A585 Windy Harbour to Skippool Improvement Scheme

TR010035

7.11 Environmental Statement Changes and Corrections Document

May 2019

Status	DEADLINE 2 SUBMISSION	Revision	1
Scale	1:2500 A3	Date	MAY 2019
Drawn By	J.NORMAN	Checked By	K.BURROWS
Approved By	N.HENDERSON	PINS No.	TR010035
Drawing number	HE548643-ARC-EGN-SZ_ZZ_000-DR-LE-30	FIGURE	FIGURE 11.4

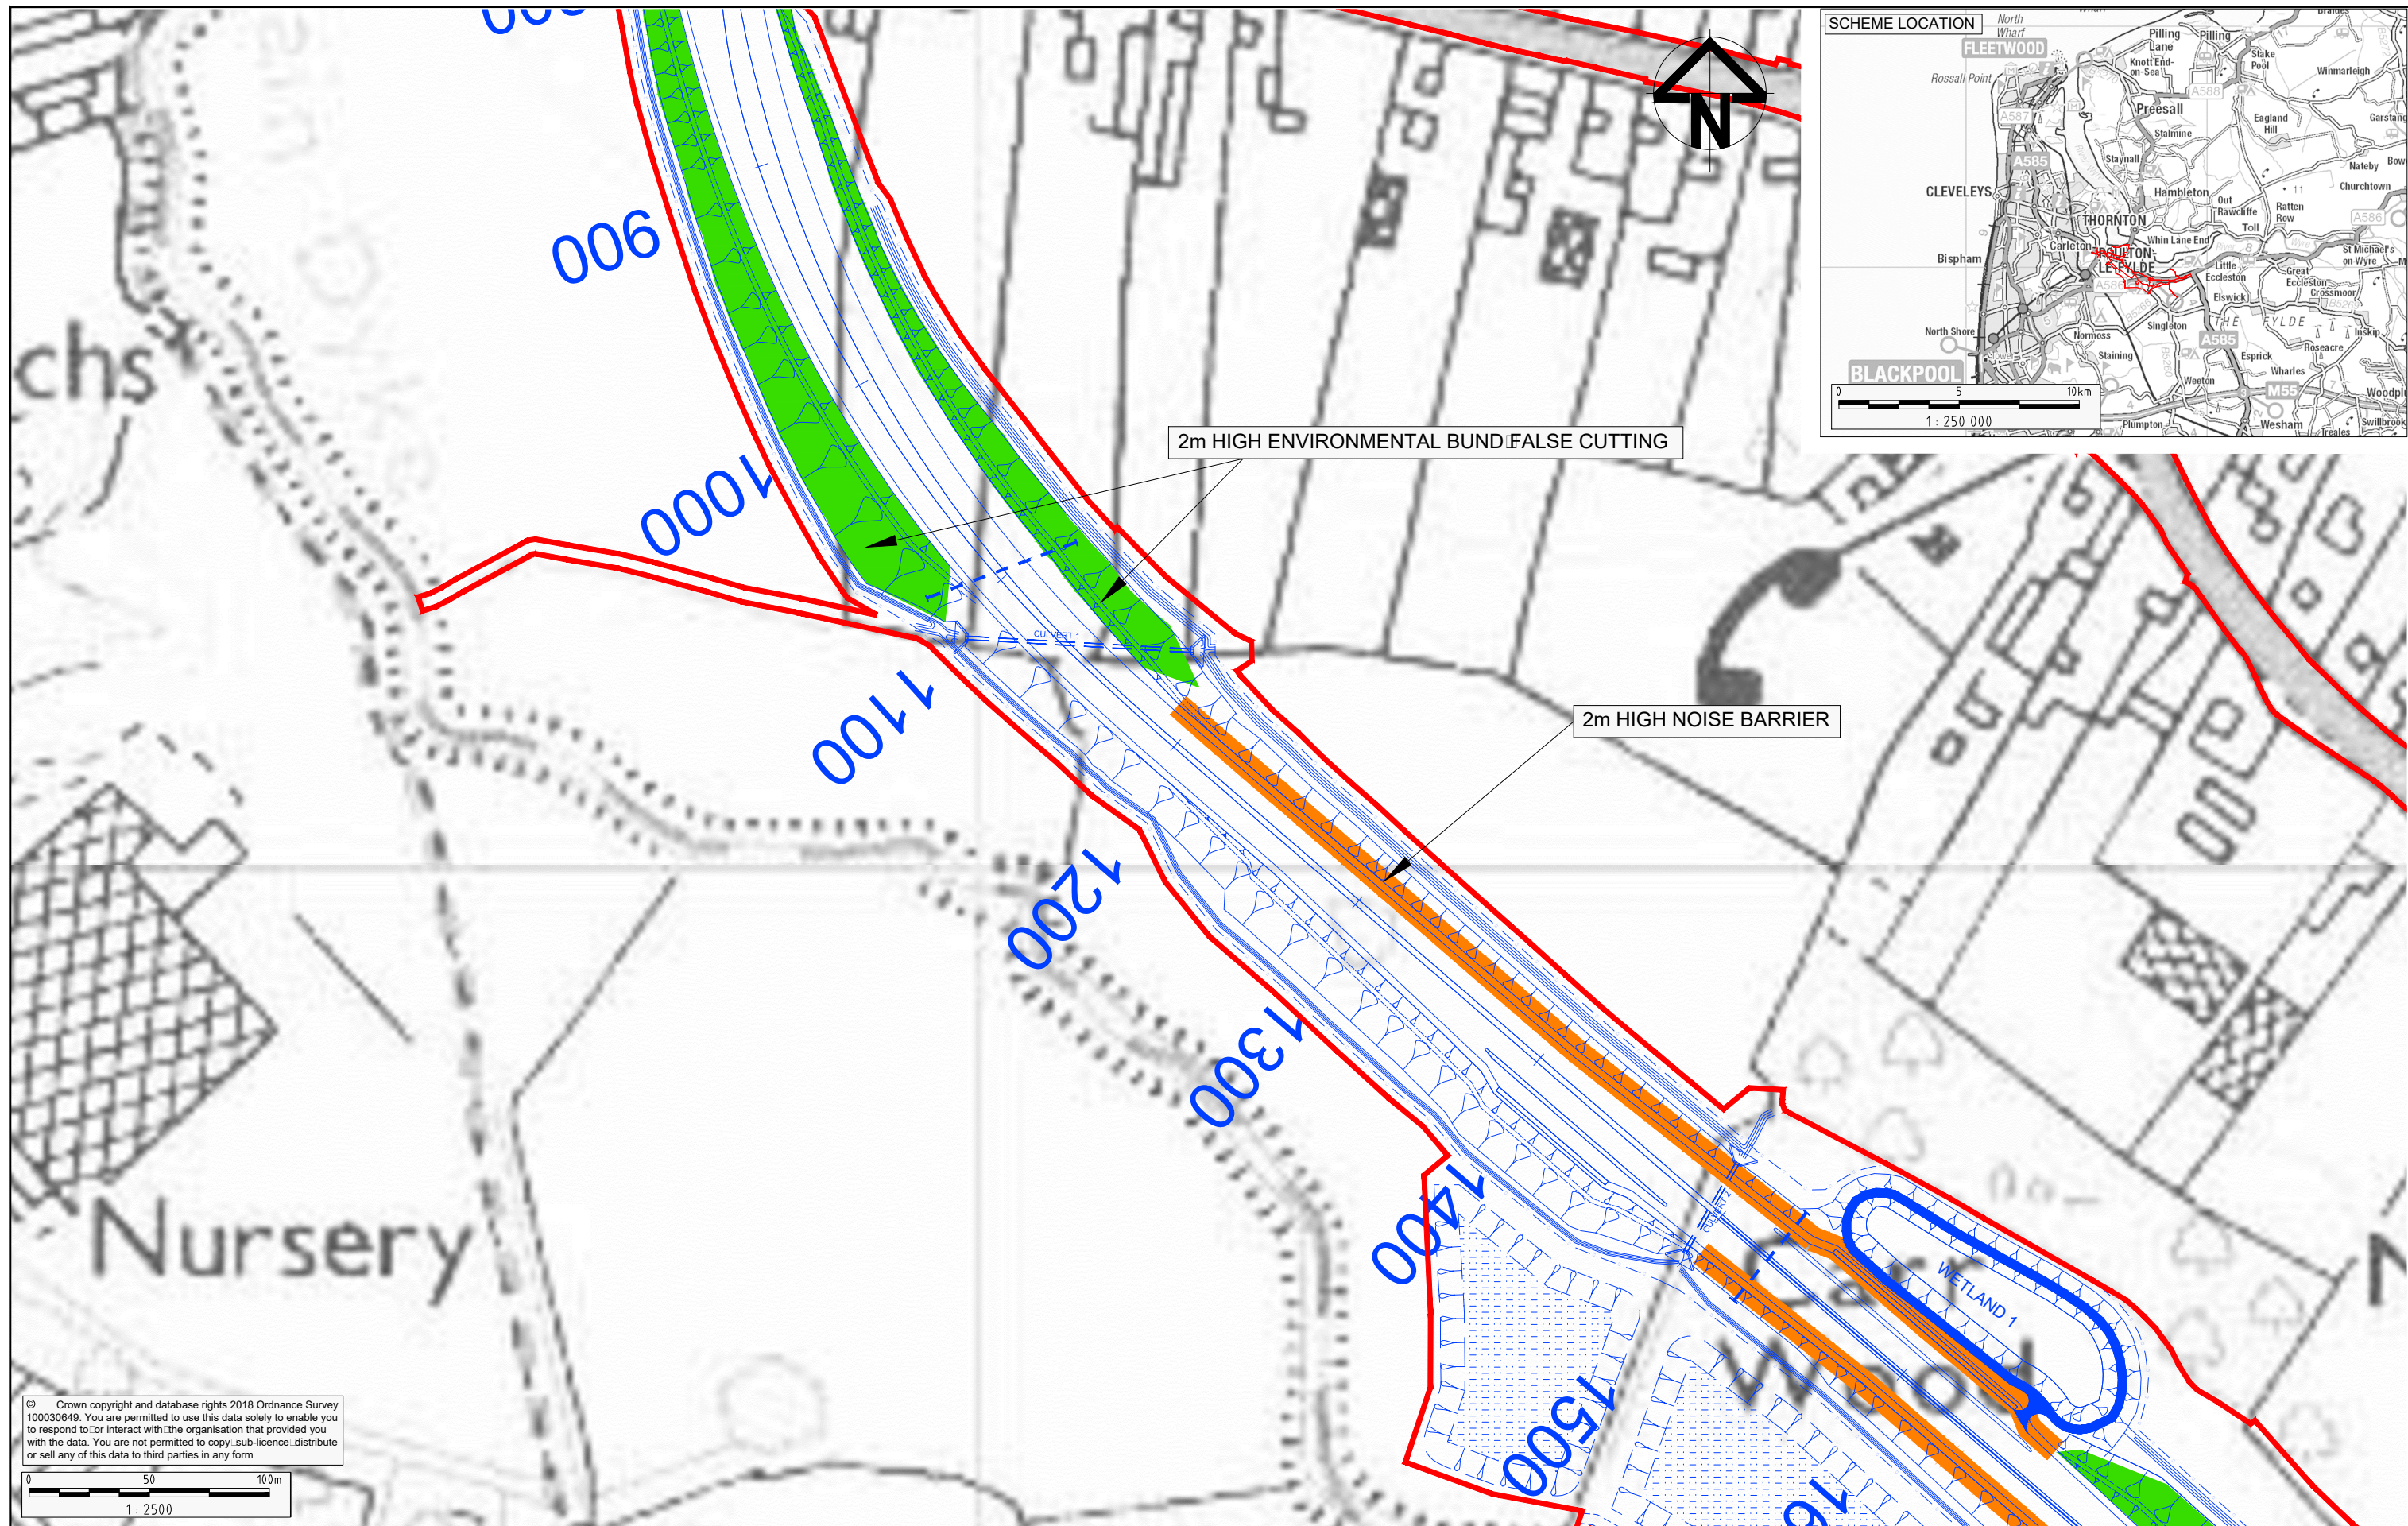
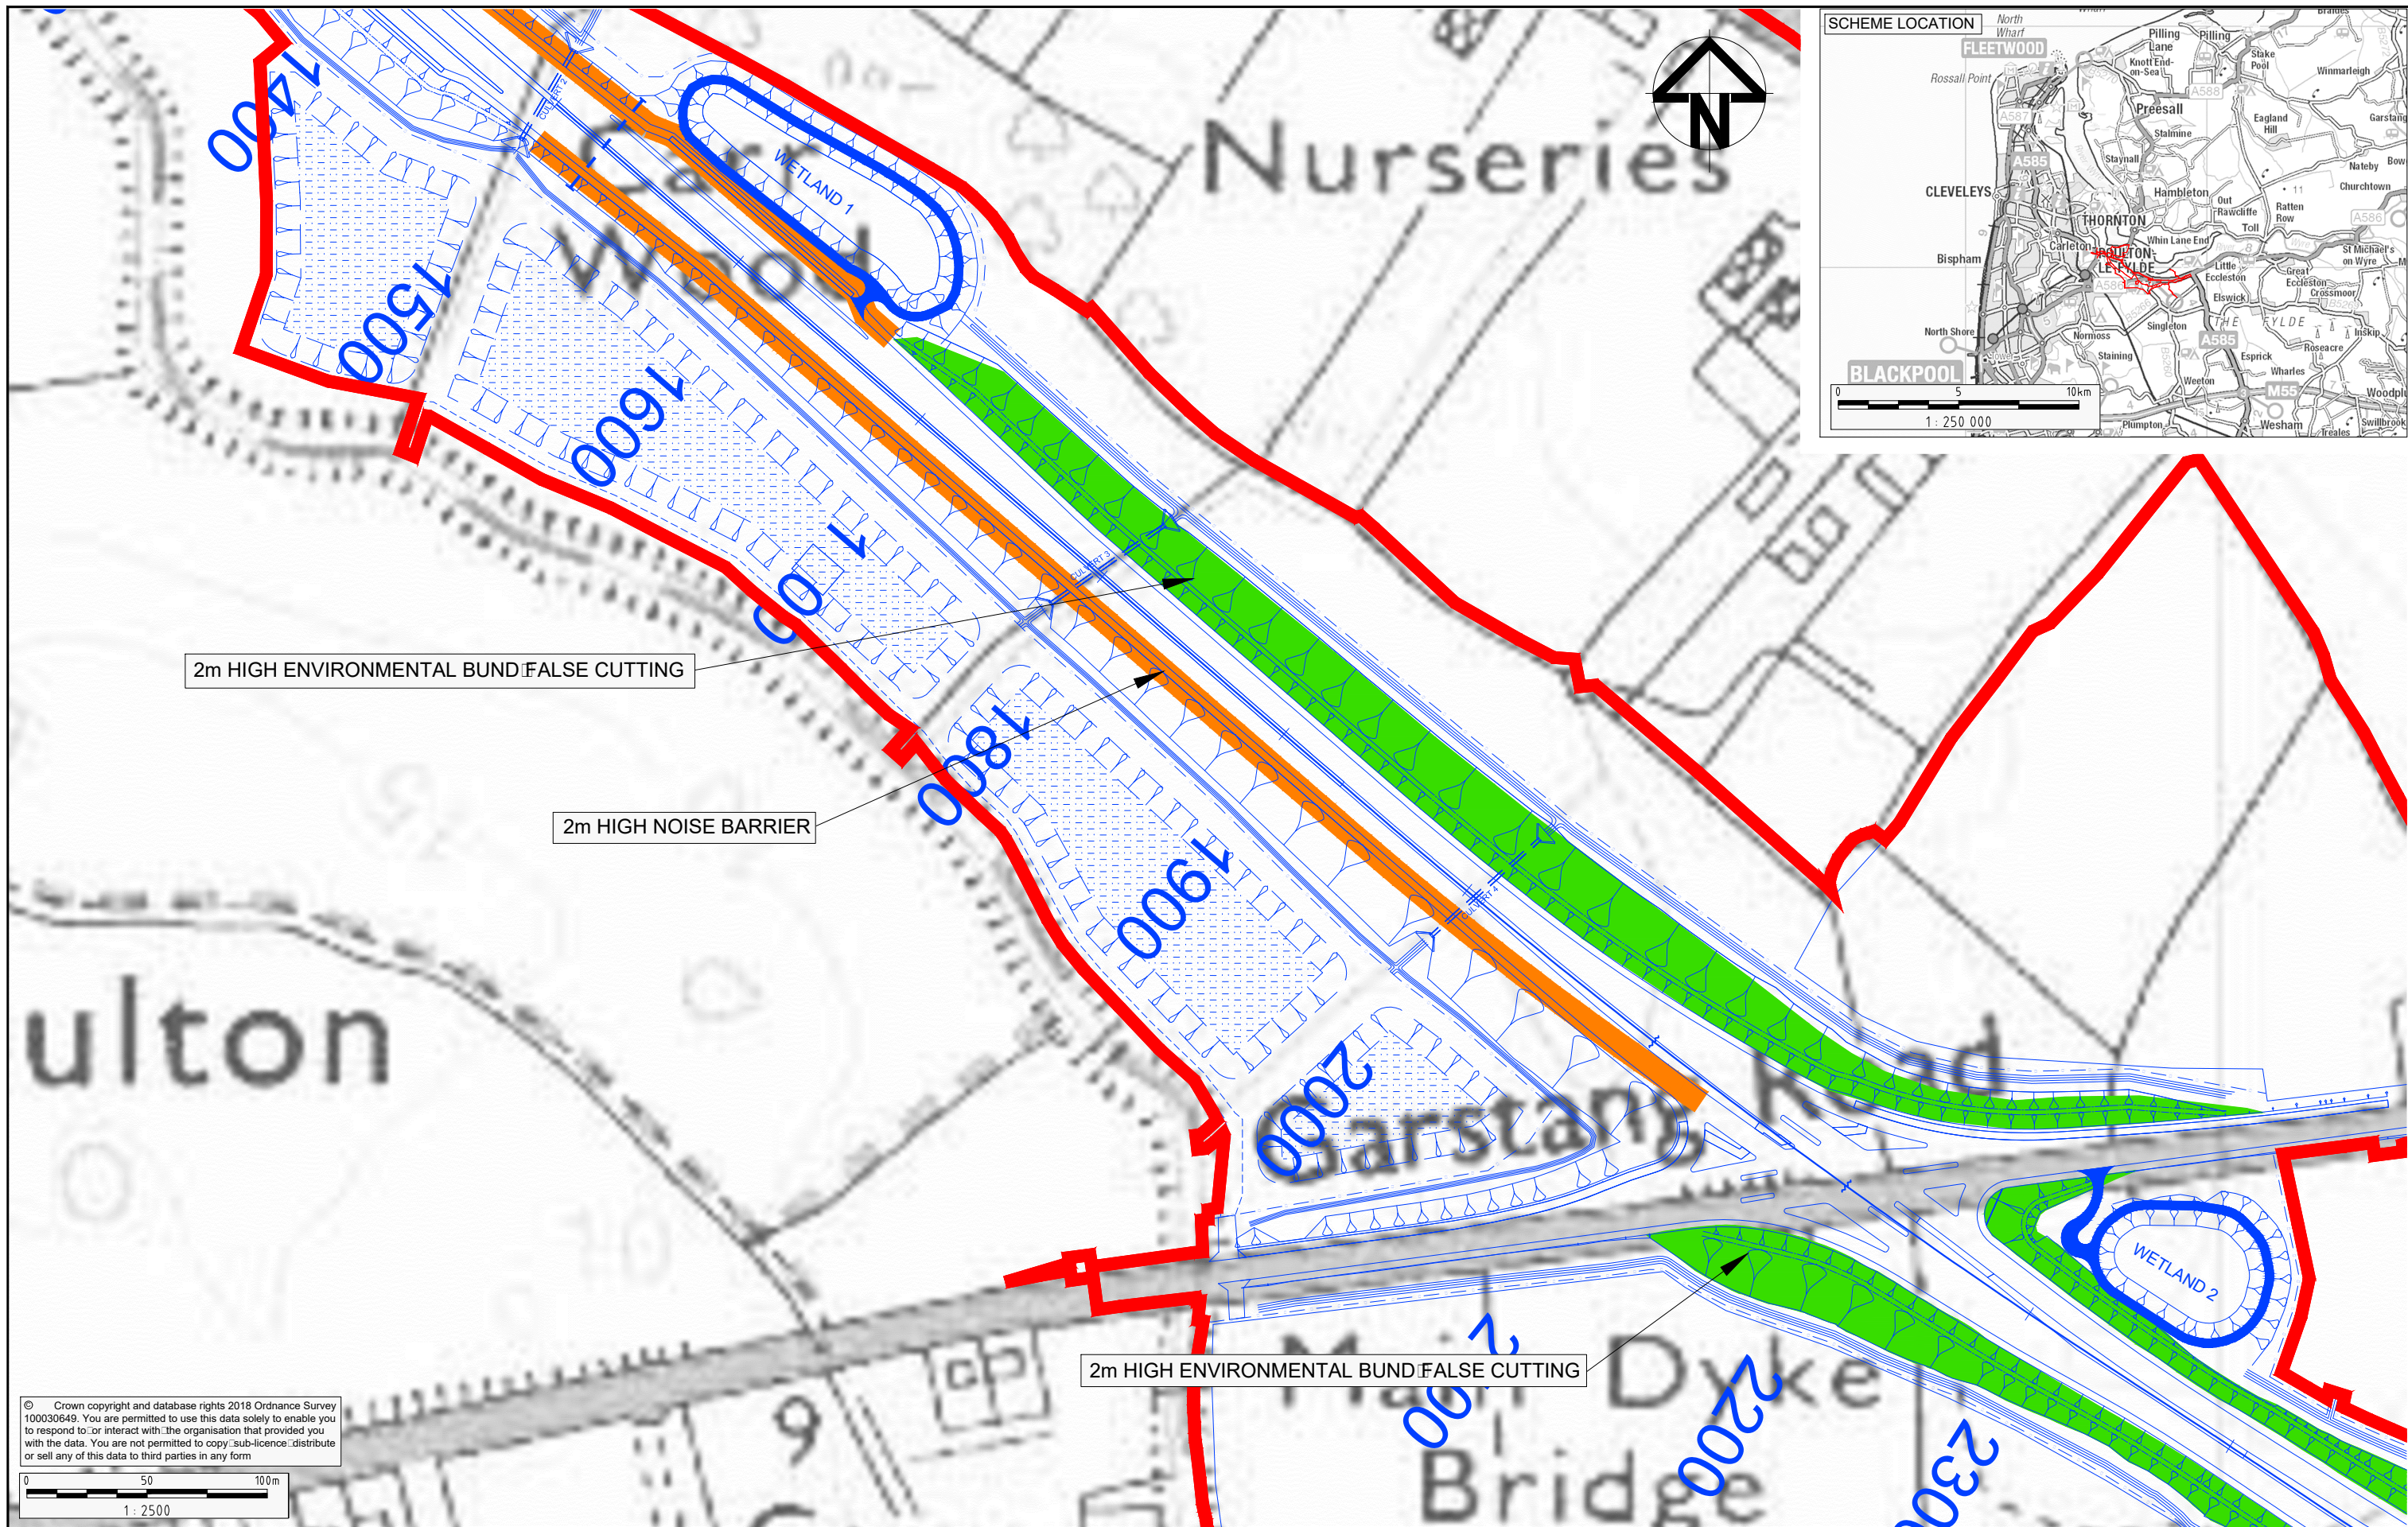
6.11	ES Chapter 11: Noise and Vibration	Update to Figure 11.4: Noise and Vibration – Noise Mitigation within the Study Area presented at Appendix D to show heights and locations of earth mounds and acoustic fencing at a larger scale.	Requested by the Inspector within the first round of written questions (document reference TR010035/APP/7.10).
